### MP10\_0097 MOD 1 - Section 75W Modification Application Spectator Precinct at Royal Randwick Racecourse – Response to Further Heritage Council Submission

We provide the following response to the further matters raised by the Heritage in their letter dated 30 January 2012.

Existing tree relocated
- 34

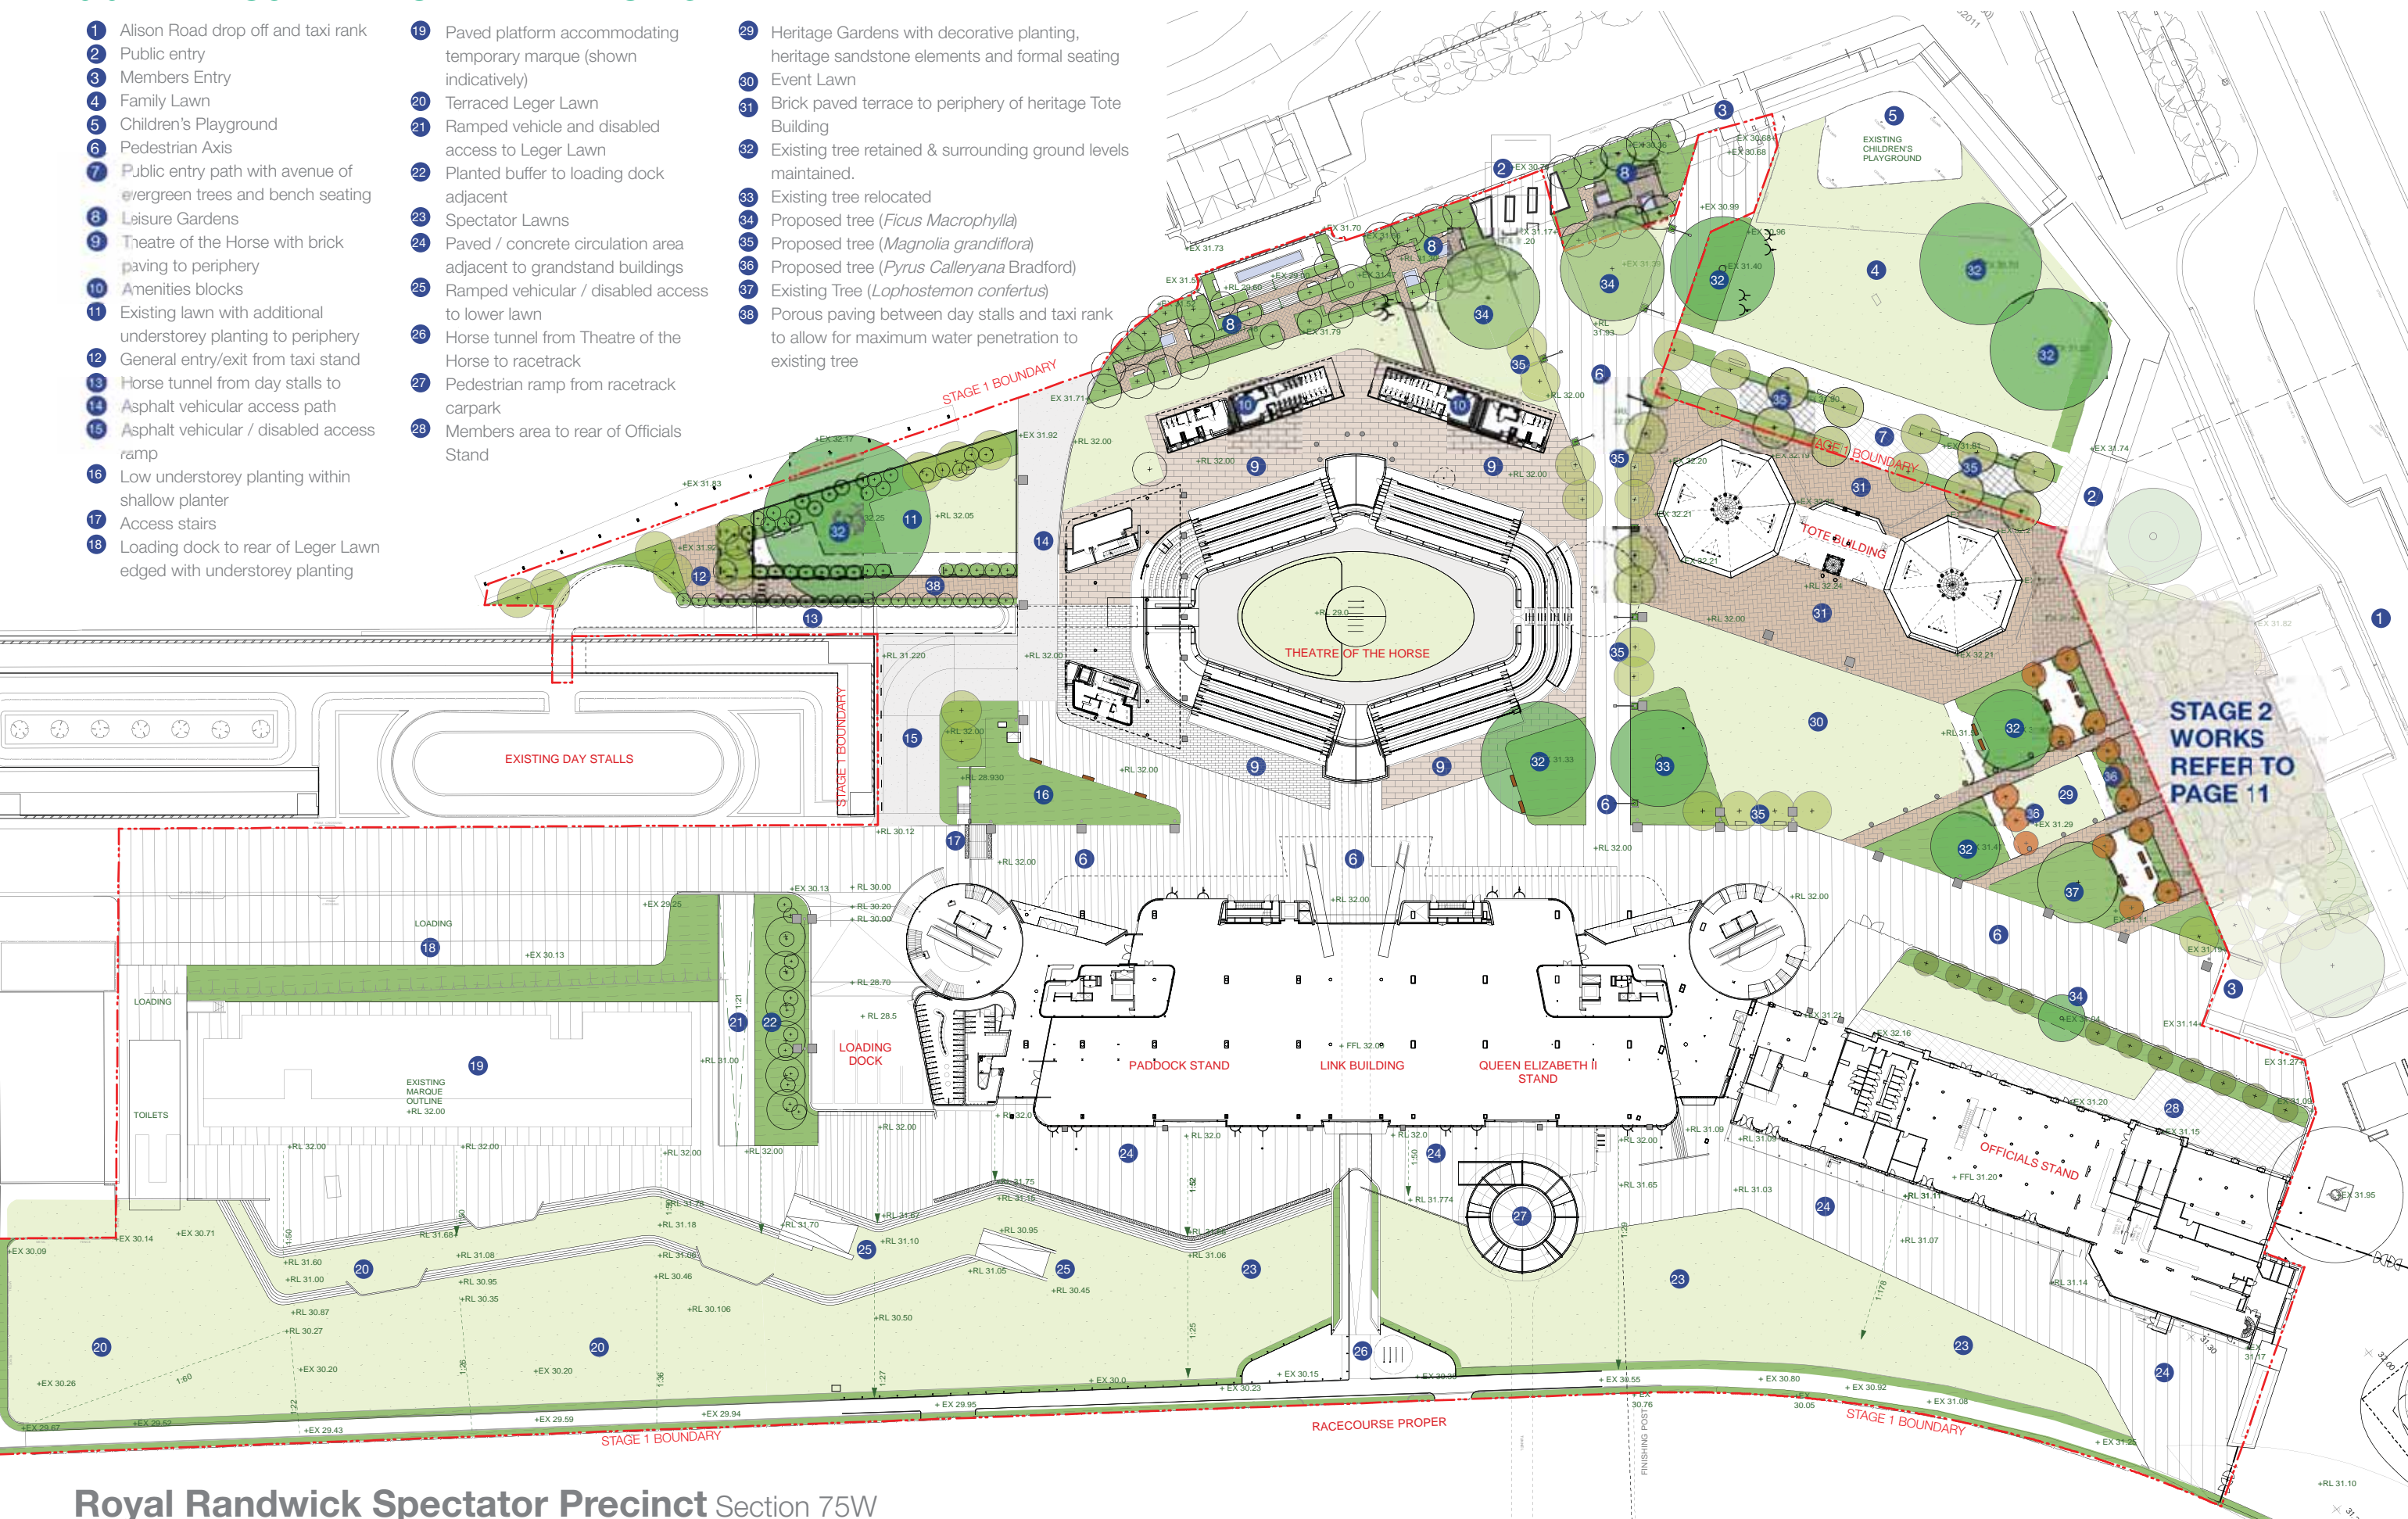
***Modification to the design and slight reorientation of the ‘Theatre of the Horse’ parade ring. This modification also entails the removal and relocation of a tree identified on the draft Royal Randwick CMP as ‘an element of exceptional significance’ and in the Royal Randwick Racecourse DCP as ‘a highly significant tree’;***

*In relation to the relocation of the Fig tree (identified as having exceptional/high significance), as previously stated the Heritage Branch accepts the comments of the project Arborist that the tree is constrained by its existing enclosure and will do better in the proposed new location. The Branch recommends consideration is given to including the following specific consent conditions:*

- *Appropriate tree protection measures shall be prepared and implemented by a qualified Arborist, with demonstrated experience working with historic trees, to the satisfaction of the Director-General of Planning & Infrastructure or their delegate. The tree protection measures should be retained and monitored for the entire duration of the works;*
- *The health and condition of the tree to be monitored for a period of 12 months with bimonthly reports on the condition of the tree provided to the Director-General of planning & Infrastructure or their delegate.*

*The Branch also recommends that the Director-General consider asking for a tree protection bond to cover like-for-like replacement in the low likelihood the tree does not survive, which could be held on trust for two years following approval of the proposed works. The Heritage Branch has no objection to the proposed new location for the Fig tree as shown on the Landscape Master Plan, provided the location is approved by a suitably qualified and experienced Arborist.*

Reports from an Arborist and a tree transplant contractor both confirm that transplanting of the significant tree is in fact feasible and practical. The Arborists Report includes a tree management plan that will be implemented to ensure the protection of the tree and a Statement of Commitment has been included in this regard. In the circumstances, it is not considered necessary to require a bond or bi-monthly reporting on the health of the tree.

6.1 LANDSCAPE MASTER PLAN - STAGE 2

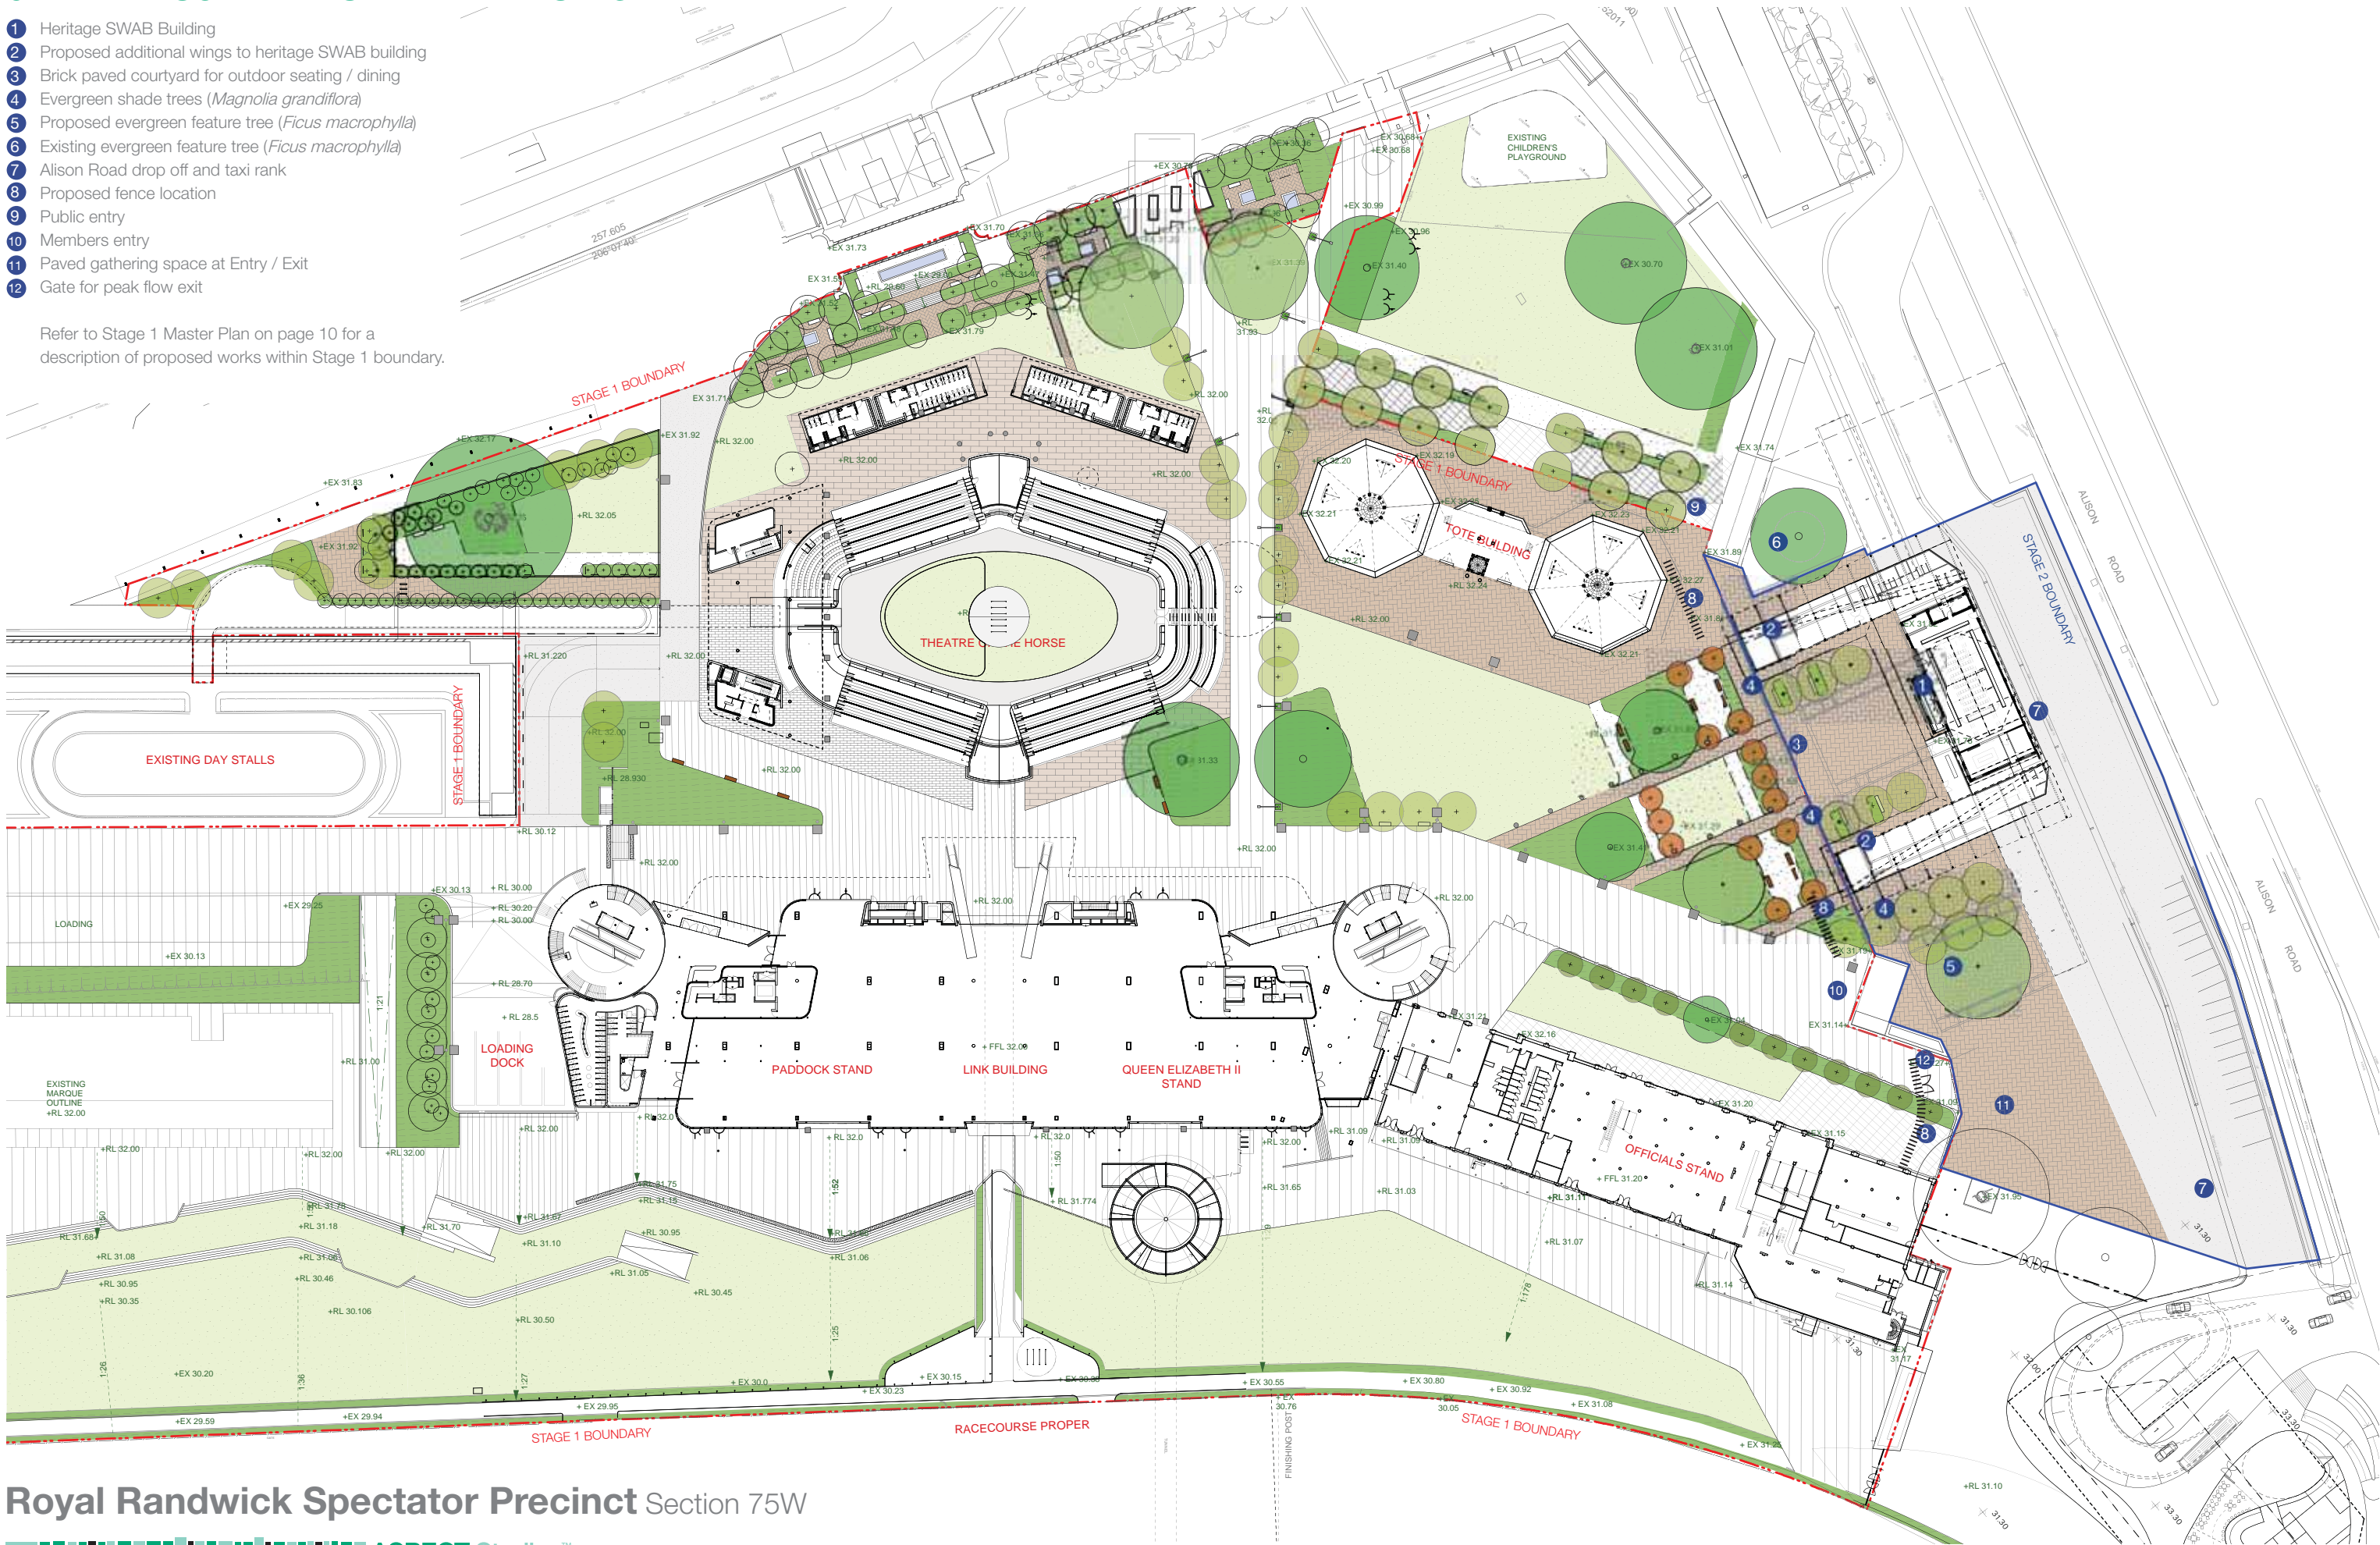
***Inclusion of a temporary landscape solution for the area adjacent to the Swab building to allow for the staged construction of works in this area;***

*While the Heritage Branch notes Graham Brooks and Associates' comment, that the amended landscape plans respond to the proposed modifications to the design scheme, neither the HIS for the 75W application or the additional information provided indicate what the 'temporary landscape solution' entails or how it 'responds' to the proposed modifications.*

*Therefore Heritage Branch is unable to provide comment on this aspect of the proposal. The Heritage Branch recommends the following condition of consent be included in any approval of the design scheme:*

- *The applicant shall provide a detailed design of modifications to the Swab Building and surrounding landscape for approval by Heritage Council when Stage 2 of the redevelopment is lodged.*

As noted in the Planning Report accompanying the 75W modification, the Stage 1 landscape works will not include any modification to the area adjacent to the Swab Building. The area adjacent to the Swab Building will remain as per that existing. As requested by the Heritage Branch, landscaping of the area adjacent to the Swab Building will be undertaken in the context of the works to the Swab Building, as per that already approved in the existing consent.
